3515 E. Blaney Rd. Peyton CO 80831\*

EDARP File Number

AL265

**Letter of Intent - 3515 East Blaney Rd, Peyton CO 80831**

SITE PLAN

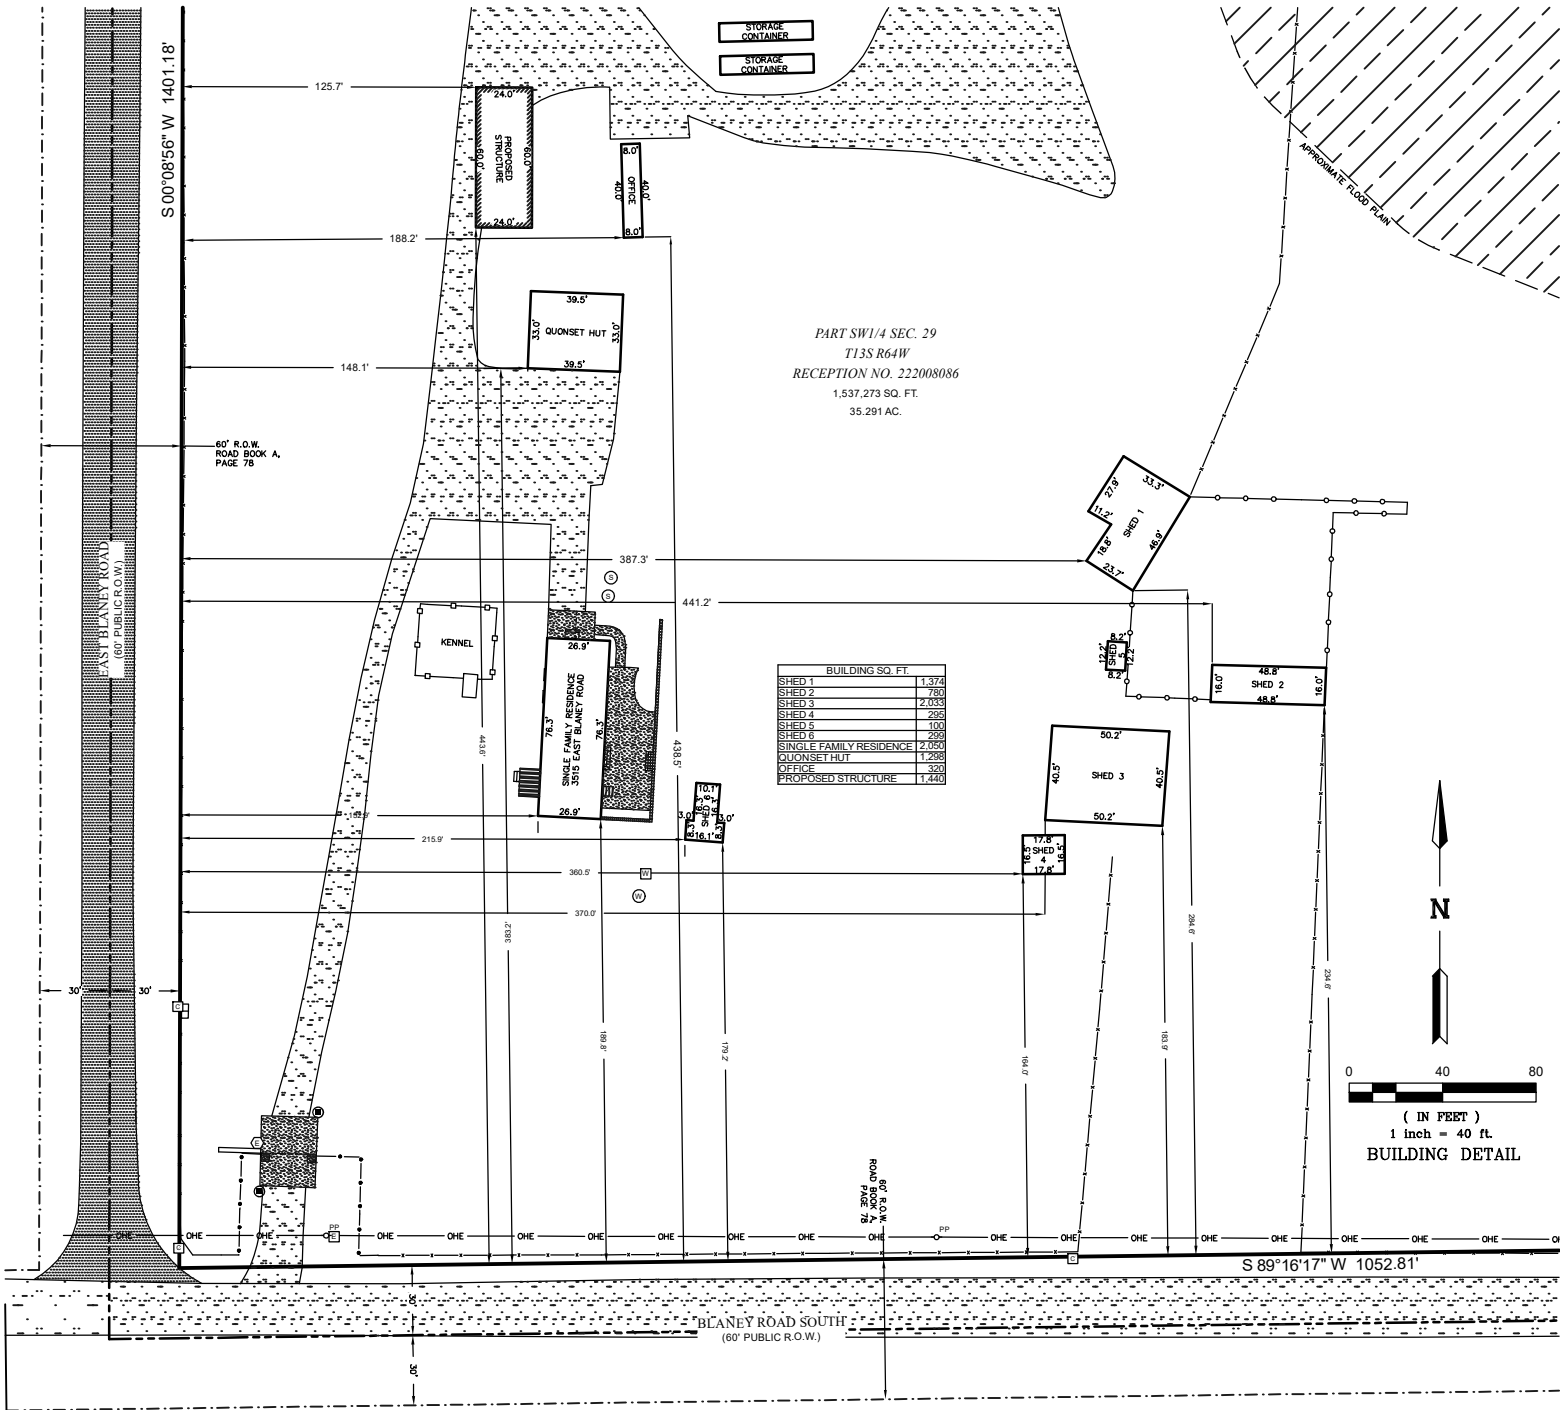
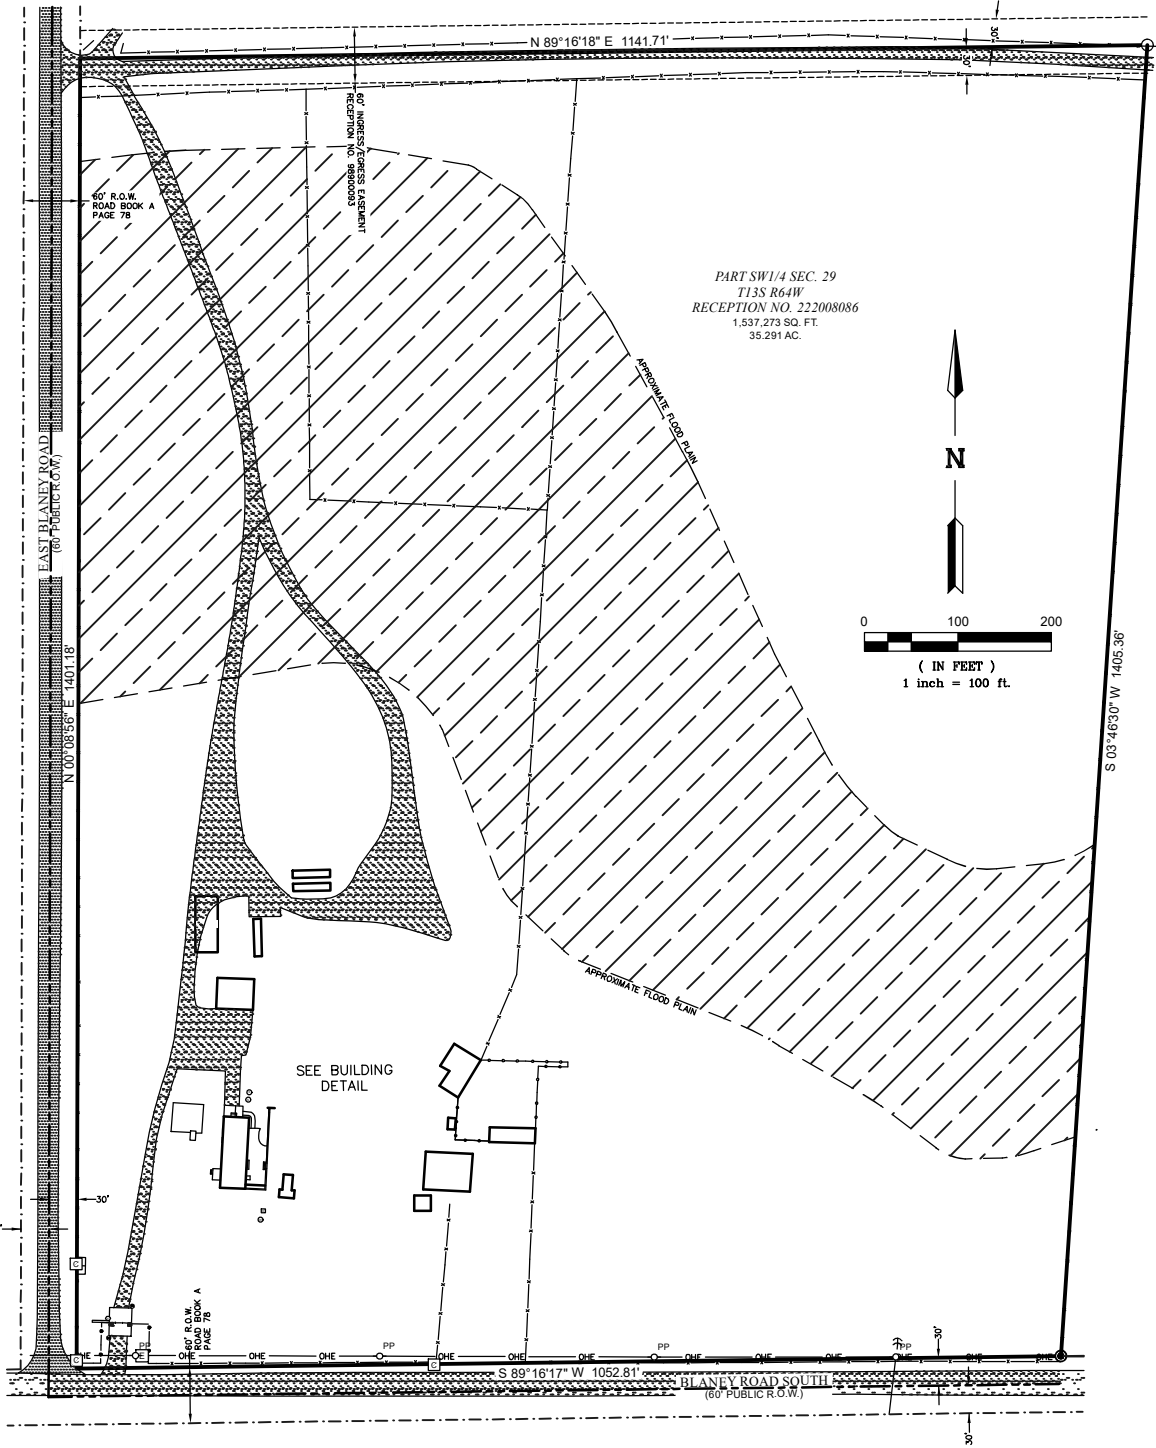
The property is within the current FEMA Zone A floodplain. The CWCB risk mapping study has developed draft BFEs for this area and the proposed storage and disturbance is shown outside of the draft BLE floodplain.

(a) **Outside Storage and Work Areas Allowed.** Outside storage, parking and work areas are allowed provided these are set-back a minimum of 50 feet from all property lines and are limited in combination to one acre or 5% of the total lot or parcel area, whichever is less. The screening standards of Chapter 6 of this Code shall apply to all outside storage areas.
